Reference: 19/05000/HYB – ****AMENDED CONSULTATION****

Site: DSTL Fort Halstead Crow Drive Halstead Sevenoaks KENT TN14 7BU

Thank you for the opportunity to comment on the above mentioned application. Further to our previous response (Letter dated: 13 November 2019, Reference: 92553), the applicant has engaged with the Kent County Council (KCC) Public Rights of Way (PRoW) and Access Service. While this engagement was welcomed, the amended plans have not resolved the issues previously raised. With reference to the enclosed georeferenced map, we have outstanding concerns that need to be addressed. The existence of the PRoW is a material consideration.

Connections – Existing Cycle and Footpaths

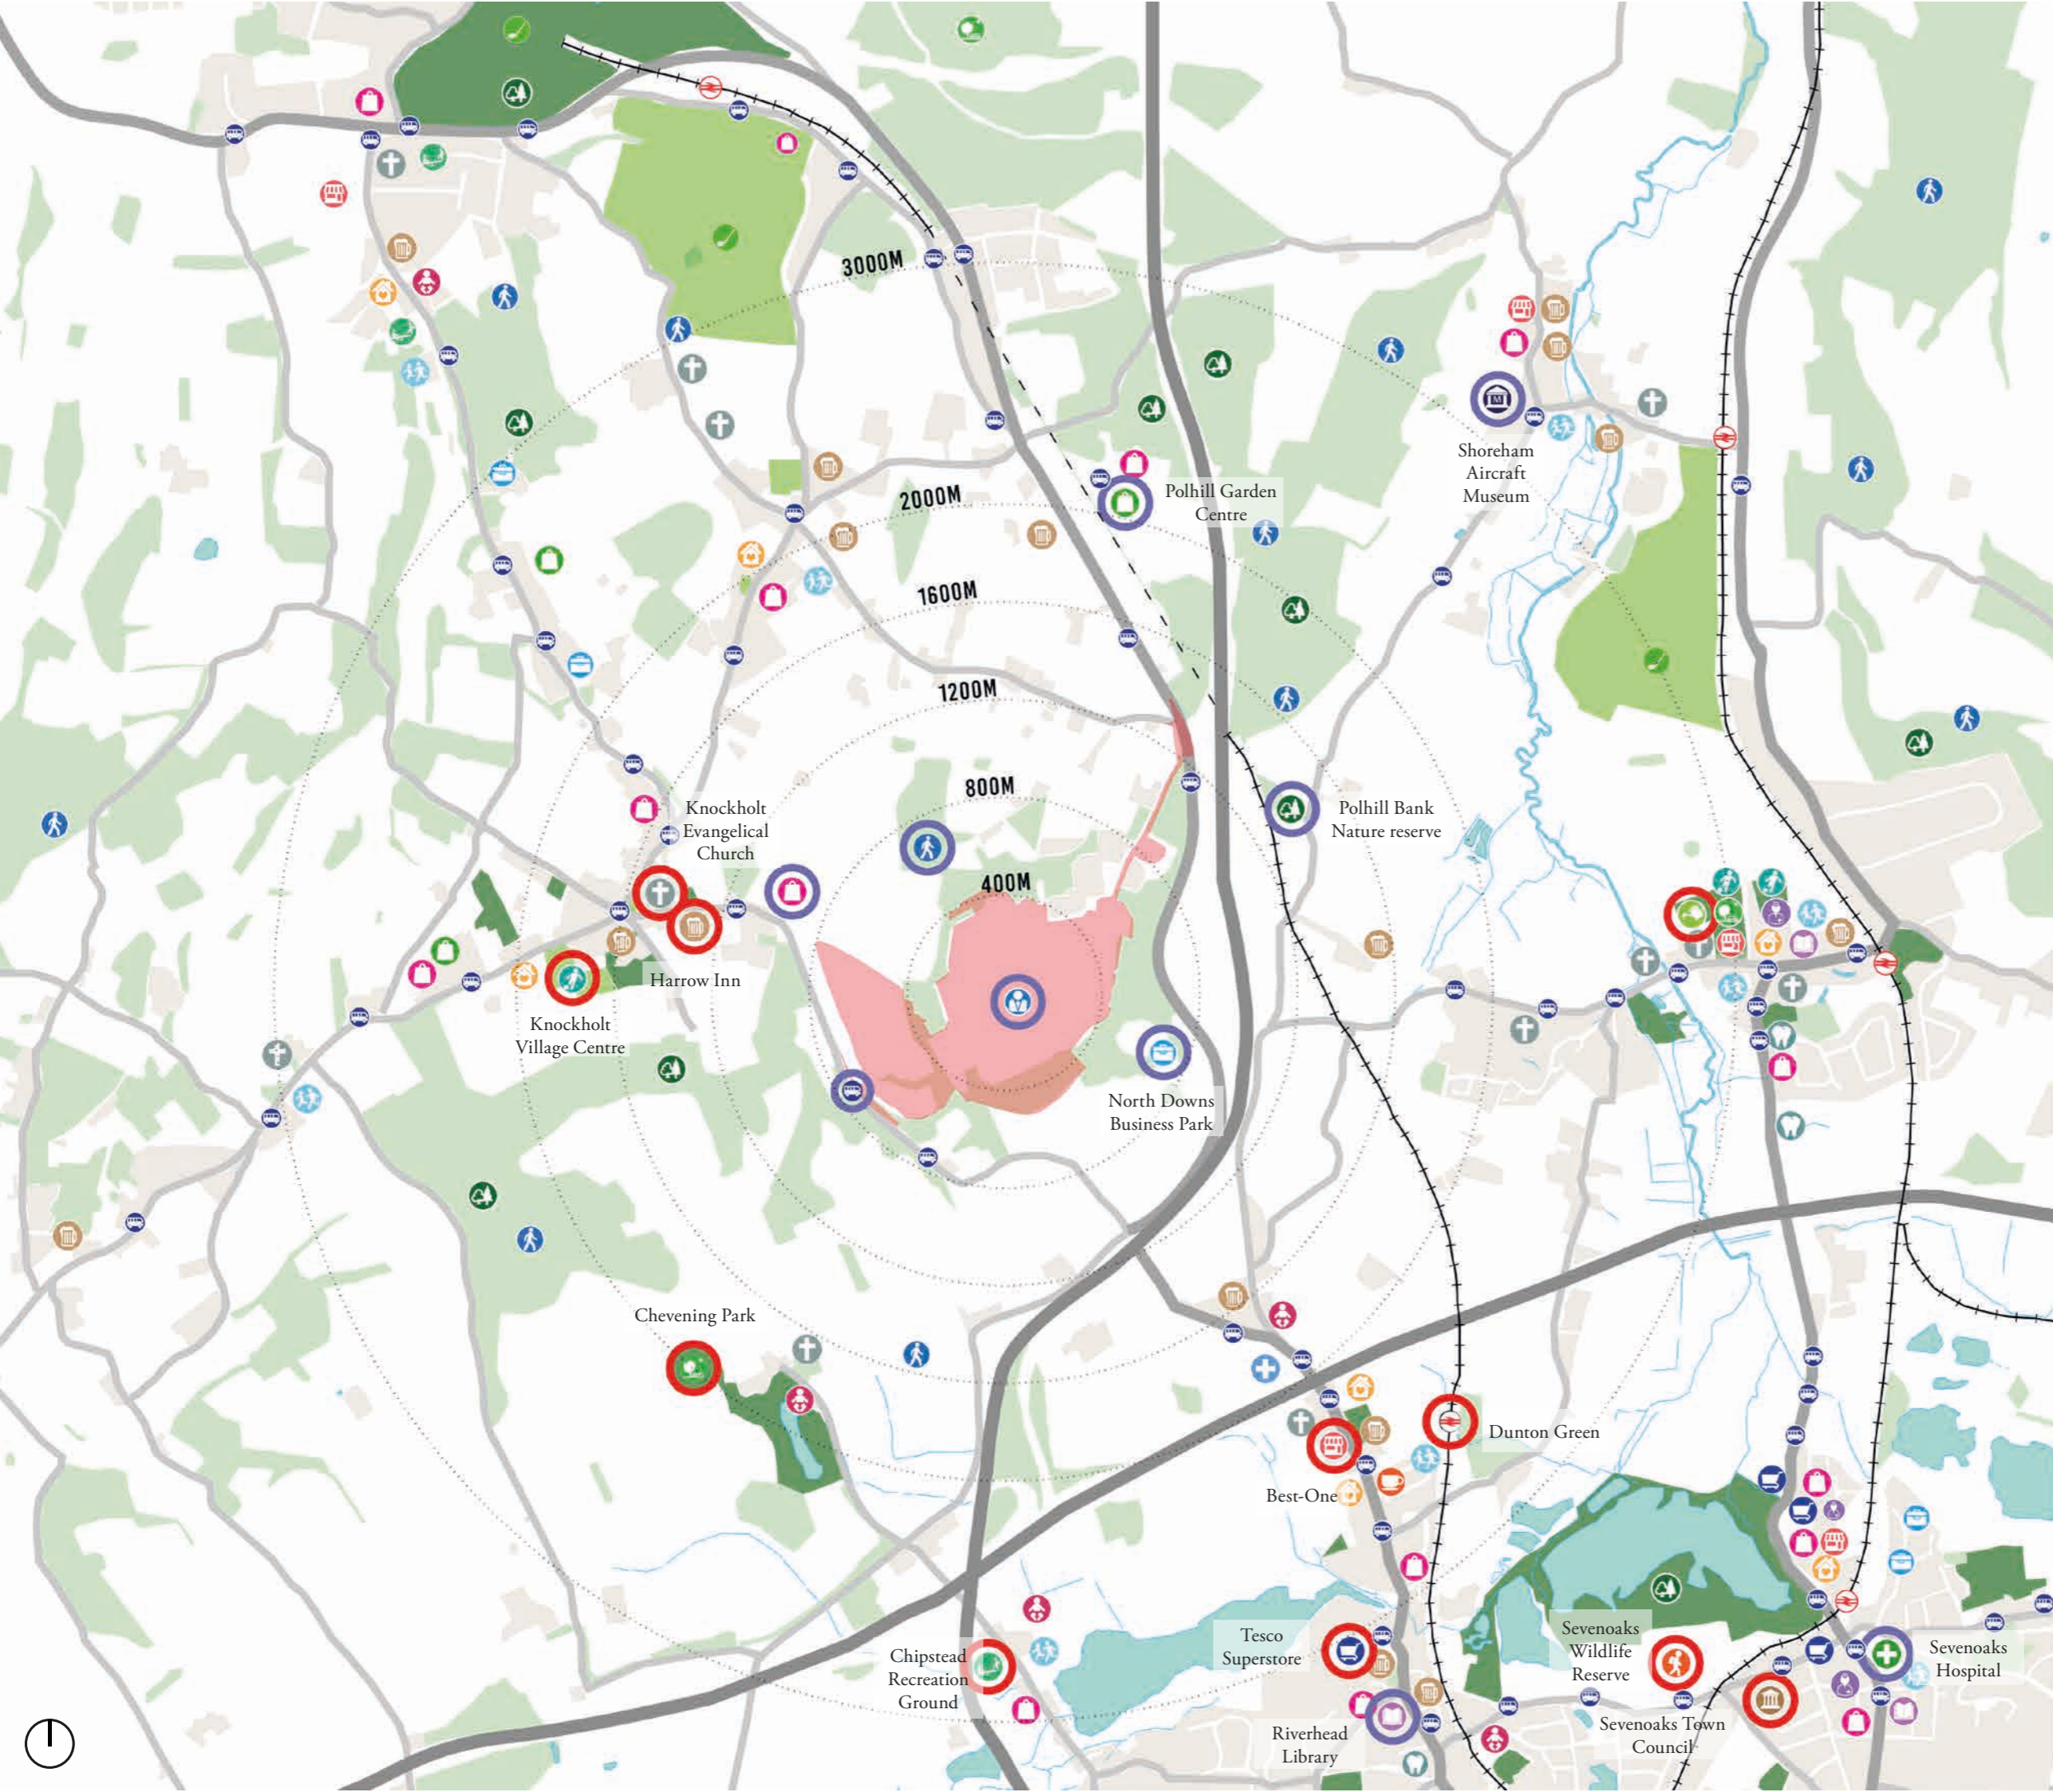
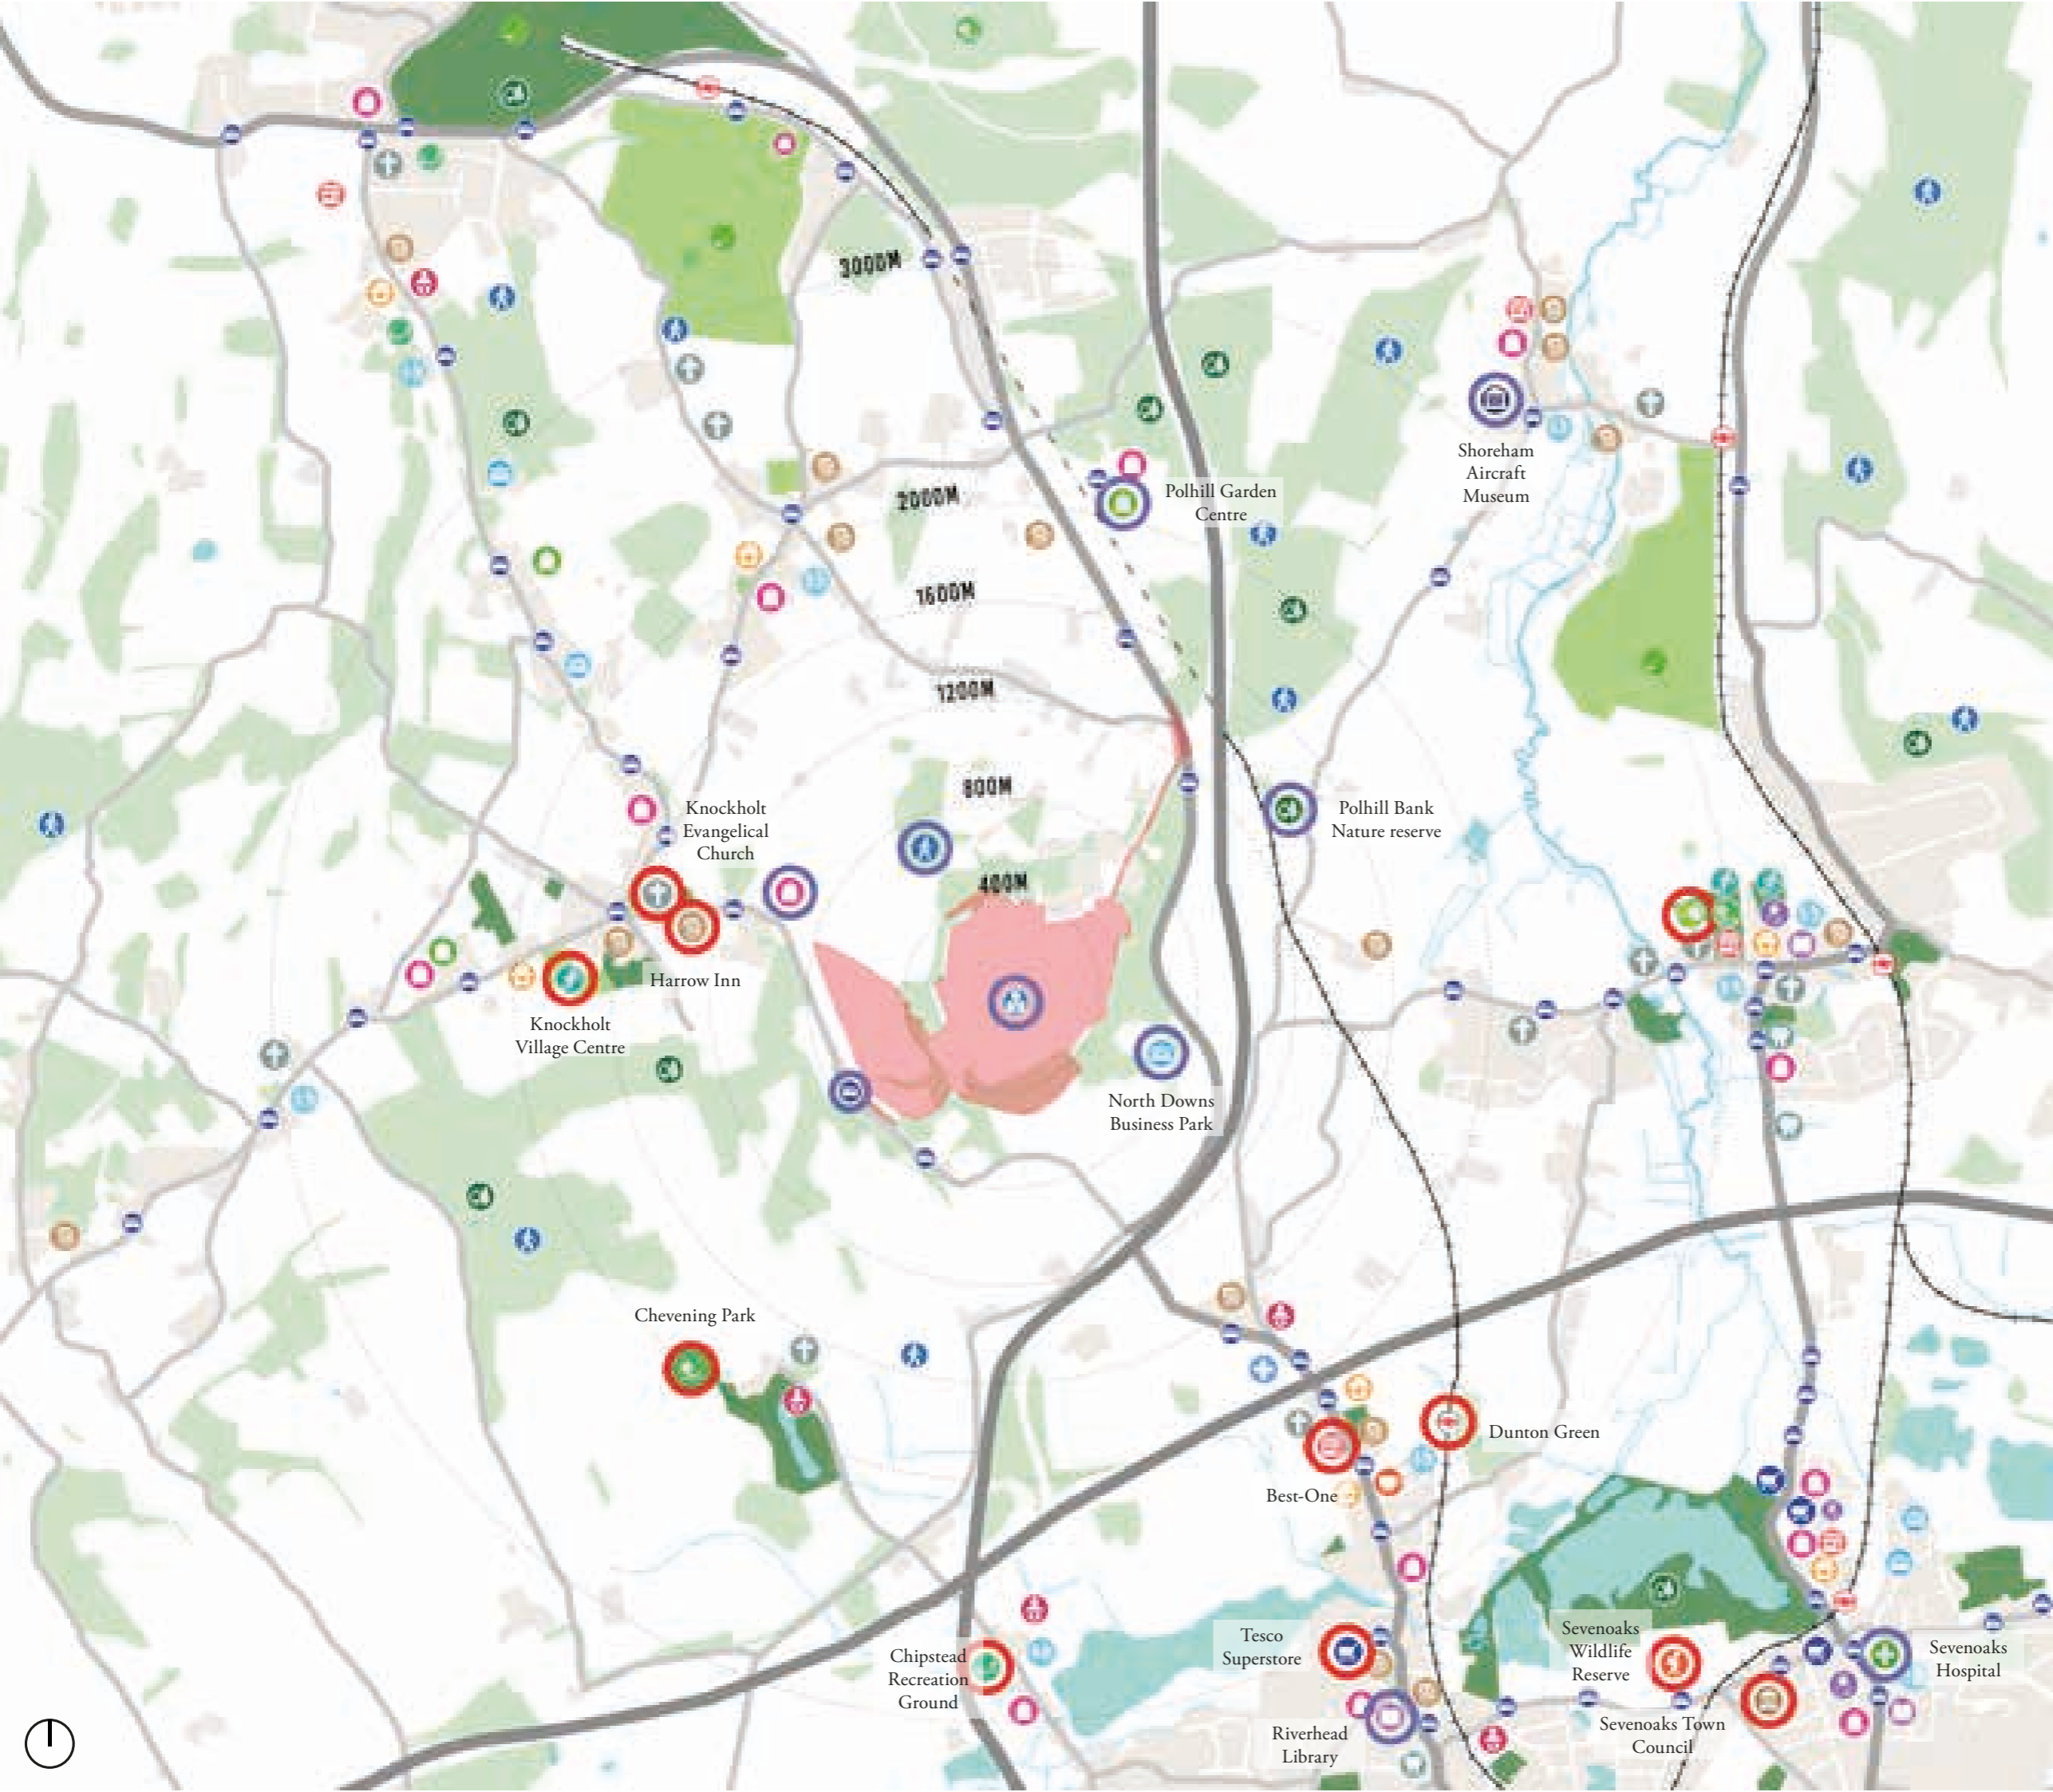
With reference to paragraph 3.23 of the 'Planning Statement Addendum', the applicant has stated that a 'new permissive cycle way adjacent to footpath SR172' will be established, providing 'a shared route for both pedestrians and cyclists to Knockholt'. We have concerns with this proposal as it is not clear how cyclists would be segregated from the existing Public Footpath. It is likely that cyclists would ride along the Public Footpath and cause a nuisance for pedestrians. Further, the promotion of a permissive cycle route along the public right of way would create ambiguity with respect to the future maintenance of the route and potential liability issues.

While the creation of new off-road cycle access is strongly supported by the County Council, the approach to delivering cycle access along Public Footpath SR172 needs to be reconsidered. With reference to our previous response, the footpath could be converted to a cycle track, but we would request that the route is upgraded to a Public Bridleway, so that it can be used by cyclists and equestrians. This could be achieved through a Creation Order (Highways Act 1980 Section 25), whereby the applicant dedicates higher access rights along Public Footpath SR172.

Disappointingly, the applicant has not considered the onward connectivity of this cycle route beyond the site boundary. The plans show that cyclists would be forced to cycle along the Old London Road, sharing the carriageway with vehicles. It is requested that the applicant considers off site improvements that would improve accessibility for cyclists and encourage active travel towards Knockholt Pound.
